14th September 2020

Application No: BR/122/20/OUT
Site Address: Garth House High Street Bognor Regis PO21 1HQ
Description of works: Outline application with some matters reserved for demolition of Garth House and West View to be replaced with 20 No. self contained apartments consisting of 10 No. 1 bed and 10 No. 2 bed apartments.

Thank you for your internet representation made on 13th September 2020 which has been recorded as an objection with the comments as follows:

Proposed Ground Floor Plan

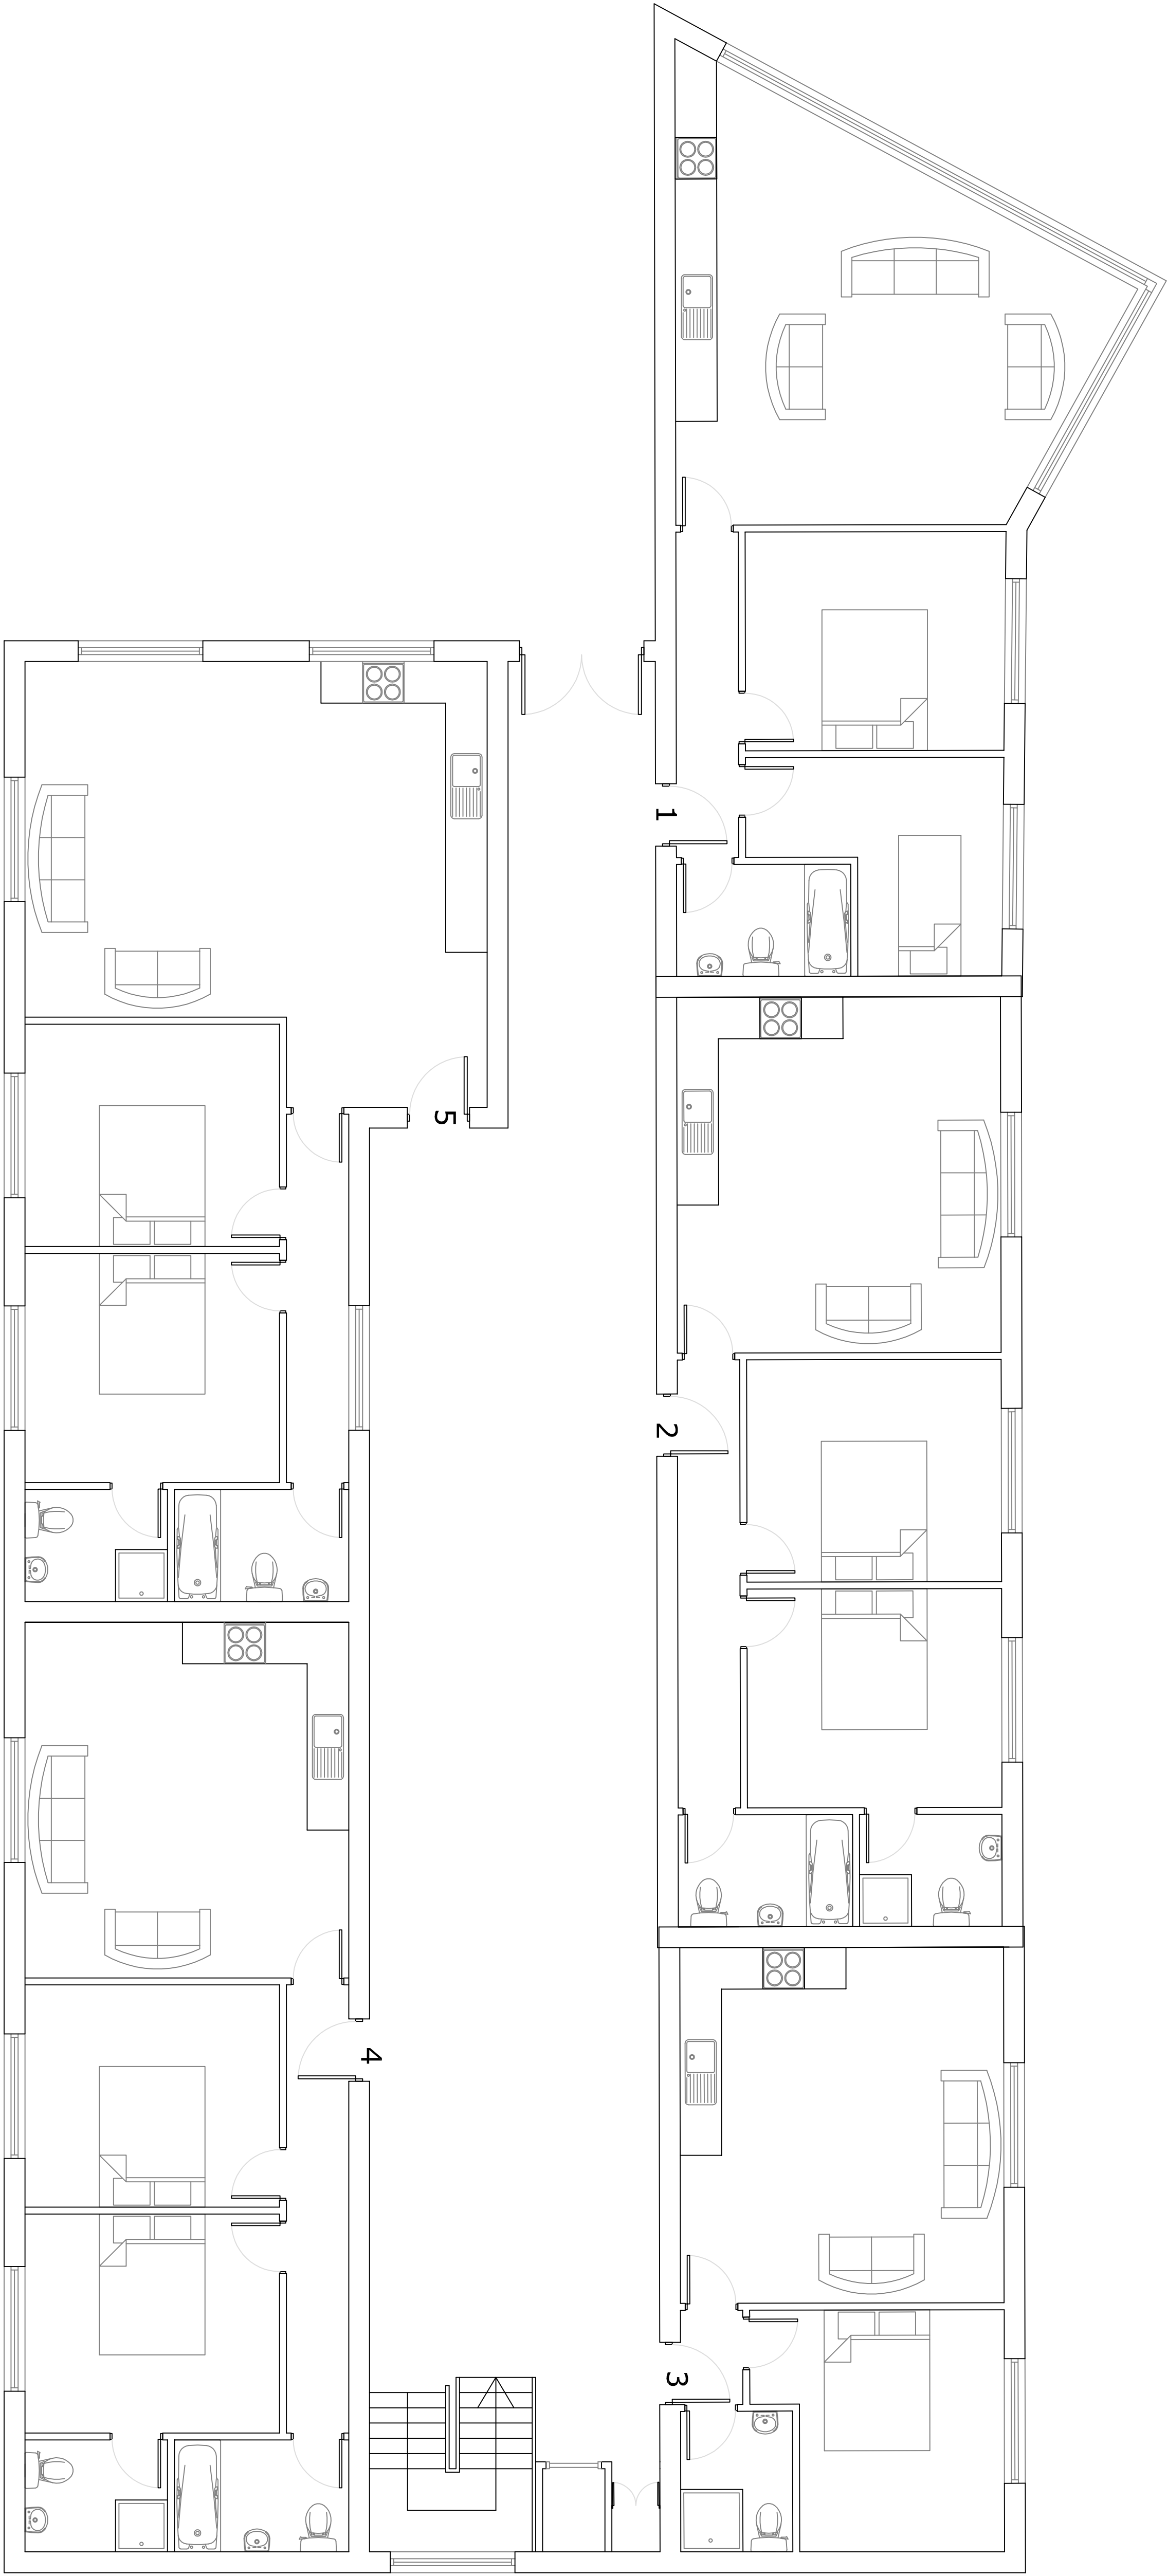
As far as I can see on the current plans provision for bin storage is inadequate. Considering Regis court (around the same number of dwellings as the proposed) has two purpose built buildings, one each for recycling and normal household waste, with c. ten wheelie bins in each, the two small squares at the front of

the proposed development are unlikely to be enough. This could lead to an unsightly overspill of waste not in wheelie bins attracting vermin and creating an unpleasant odour.
